SUBMISSION TO WESTCONNEX M4 WIDENING EIS

Submission to EIS for proposed WestConnex M4 Widening

This submission has been prepared by Holroyd City Council in relation to the Environmental Impact Statement (EIS) for the proposed widening and upgrade of the M4 Western Motorway between Pitt Street, Parramatta and Homebush Bay Drive, Homebush.

Figure 8.9 Photo of the existing spaces beneath the viaduct

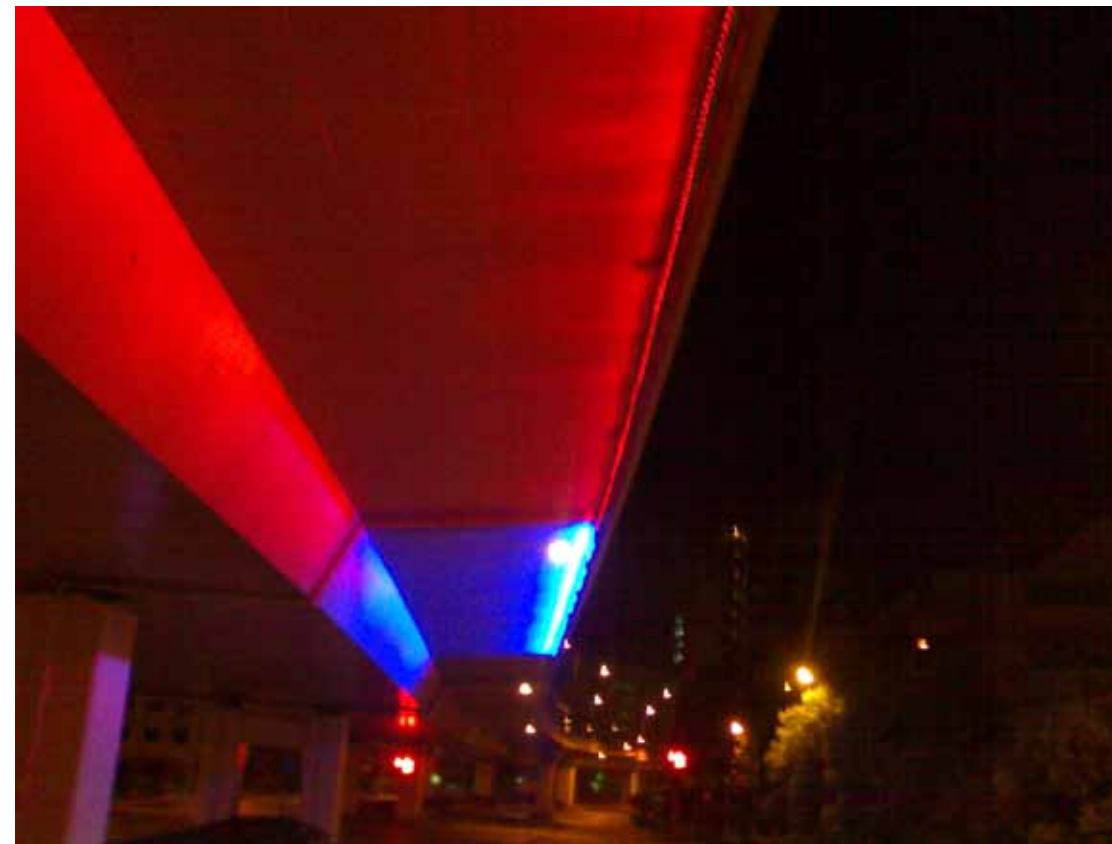
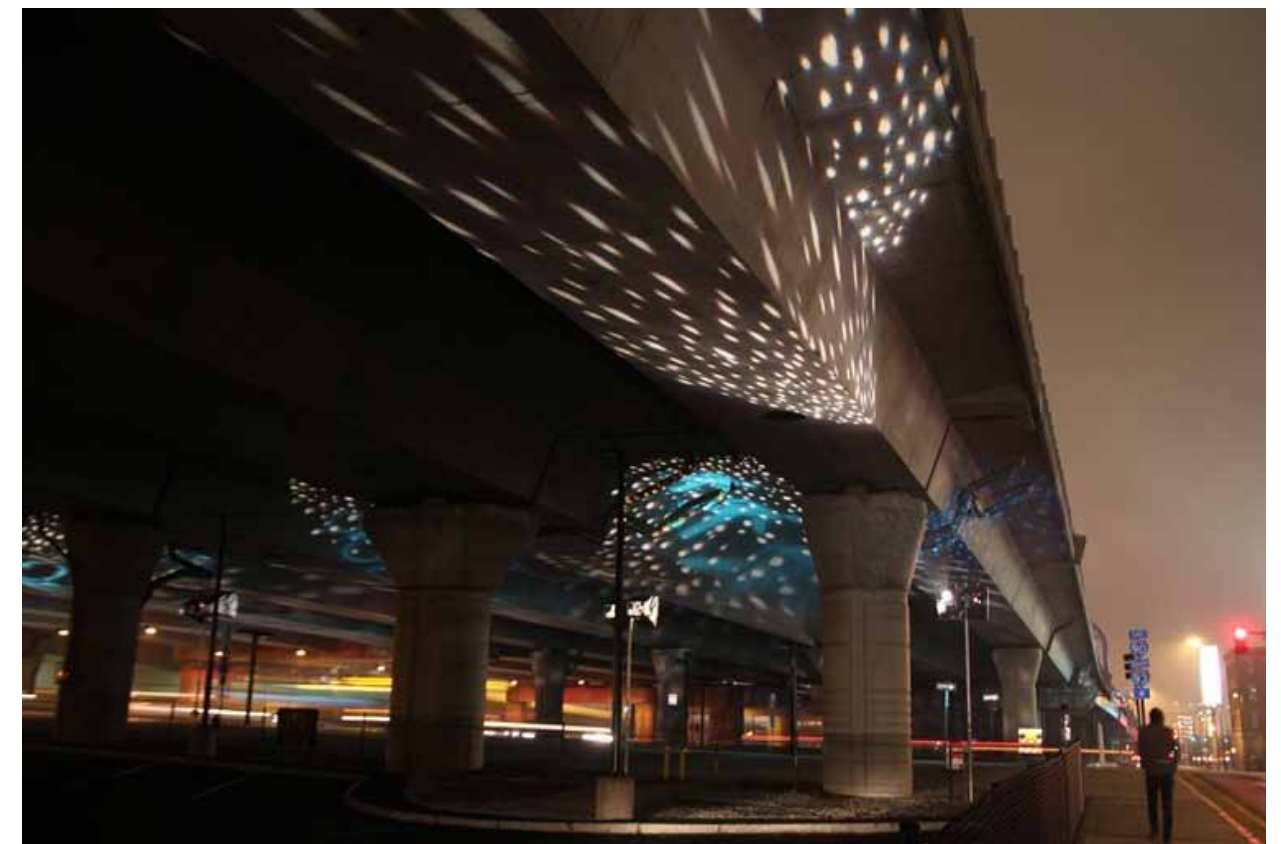
The use of feature and linear lighting is proposed for areas under the viaduct that incorporates Crime Prevention Through Environmental Design (CPTED) principles. The installation of interpretive artwork expressing Parramatta both underneath the viaduct and on the noise walls is also proposed.

In accordance with the objectives of the M4 widening project, greater consideration should be given to the undercover area of the current and proposed viaduct, between Church Street, Junction Street, A'Becketts Creek and the railway underpass. The current amenity of the under-cover area is limited by anti-social behaviours caused by the shelter provided by the existing viaduct, and additional viaduct coverage is expected to exacerbate this issue. It is therefore recommended that the potential for a more beneficial or constructive utilisation of the area, as well as improved urban design outcomes, be investigated. This should include the acquisition/amalgamation of the covered properties for the provision of community open space, the dispersal of carriageway stormwater runoff for the irrigation of the covered ground below, and the provision of greater integration of the overall landscape treatment of the covered area including paving, vegetation and decorative lighting.
